From: Roger Spencer
Sent: 12 February 2018 16:34
To: Ross Leal
Cc: Engineering.Services
Subject: RE: LU/404/17/PL - 2-6 Beach Road, Littlehampton

Subject: LU/404/17/PL - 2-6 Beach Road, Littlehampton

GROUND FLOOR PLAN AS PROPOSED WITH SITE + LOCATION PLANS
 2-6, BEACH ROAD, LITTLEHAMPTON
 GRAHAM NICOLLS LTD. BUILDING DESIGN + TECHNOLOGY TEL/07990 522709

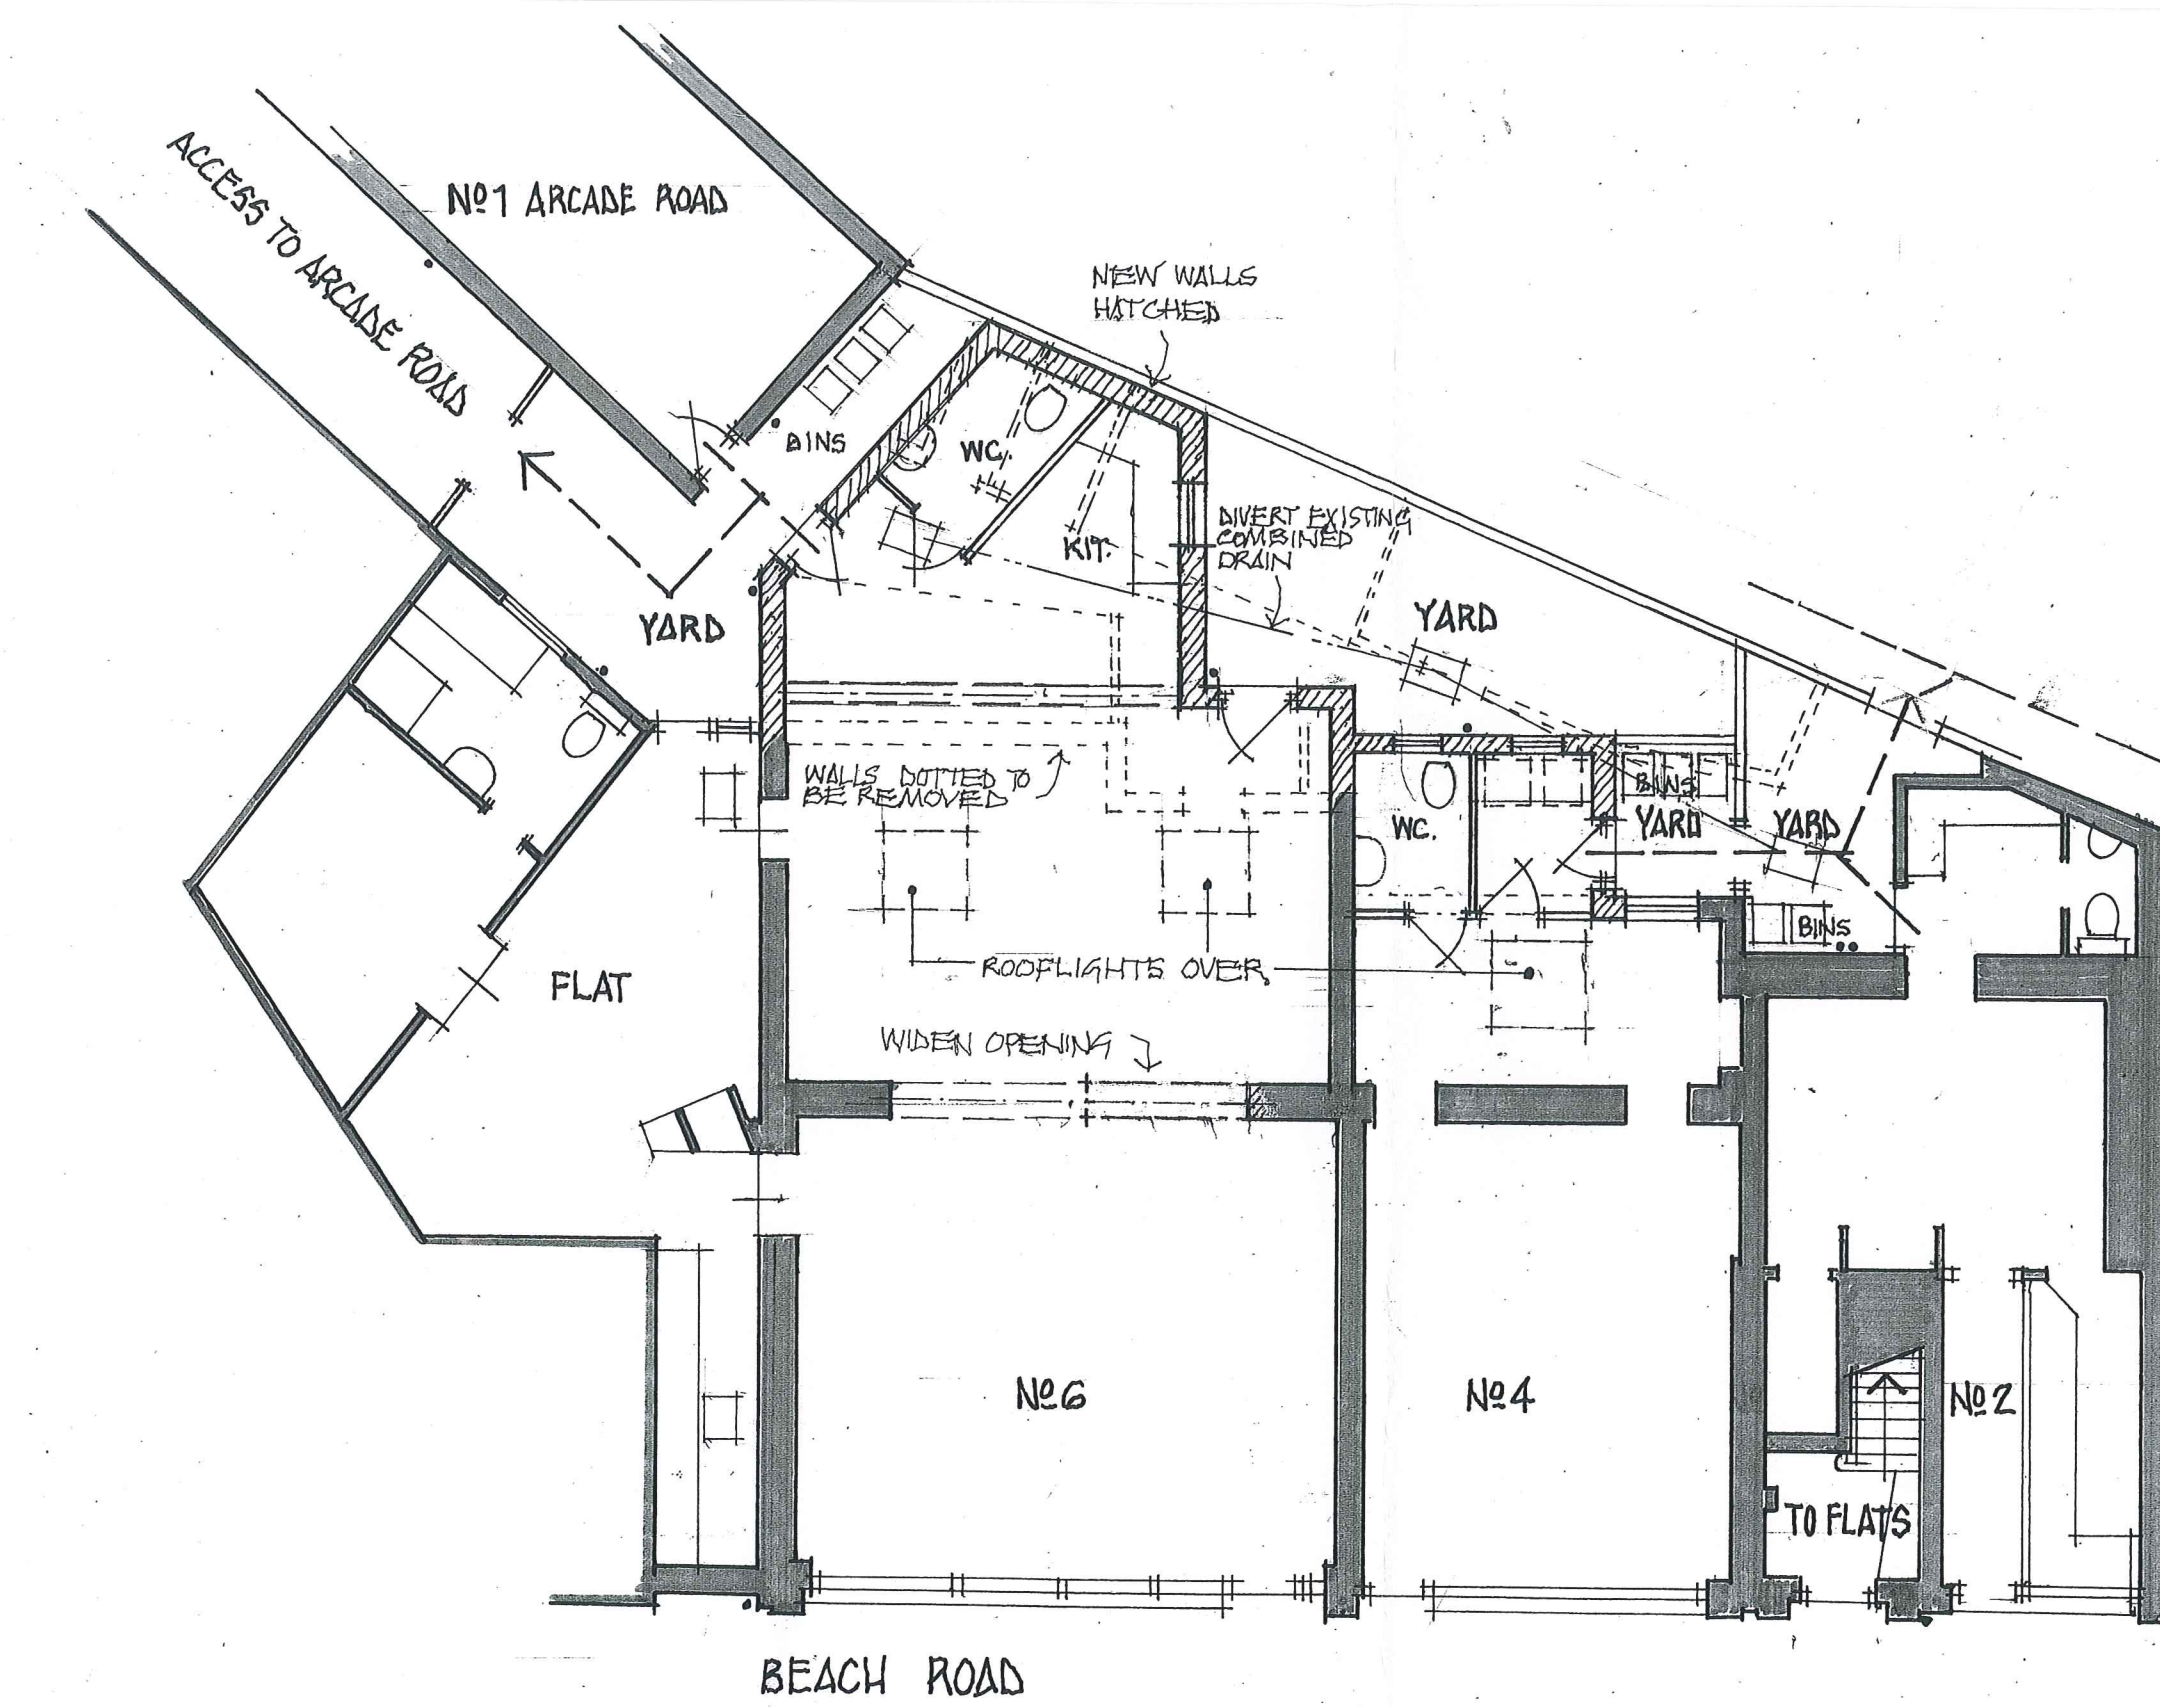
In view of the fact that the site is within FZ 2 & 3, I recommend that a condition is imposed regarding the installation of suitable flood resilience measures.

Further, as the site has suffered sewer related flooding, I suggest an informative be attached, regarding contacting Southern Water Services in relation to considering the efficacy of installing other flood defence measures such as bolt down drain covers and / or non-return valves on the drains.
